Proposed Development
LU/56/18/PDH

Reference to the proposed Development to 58 South fields road, Littlehampton, BN17 6PA
LU/56/18/PDH

DWG NO 580/01 **REV.**

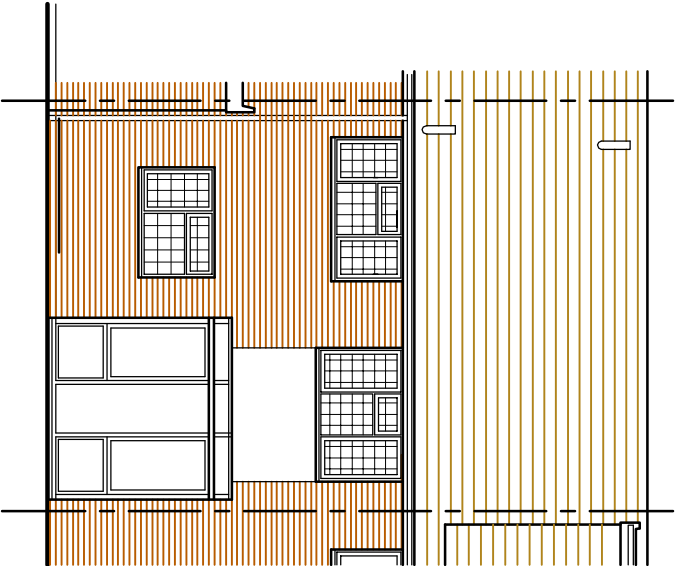
We feel we must object to the proposed drawings by Sloane and Brown showing the external wall of our Exsisting Extension as a Party wall. This is completely wrong.

Drawing numbers 580/04 and 580/01 showing the rear elevation

If the Council still keeps past planning application details for 1983, Drawing no C8782/1 You can clearly see that the Boundary line runs along the face of our wall, Making it a Boundary wall not a party wall. (I do have a copy of these drawings if needed) We Feel this needs to be corrected to avoid any Future Misunderstandings.
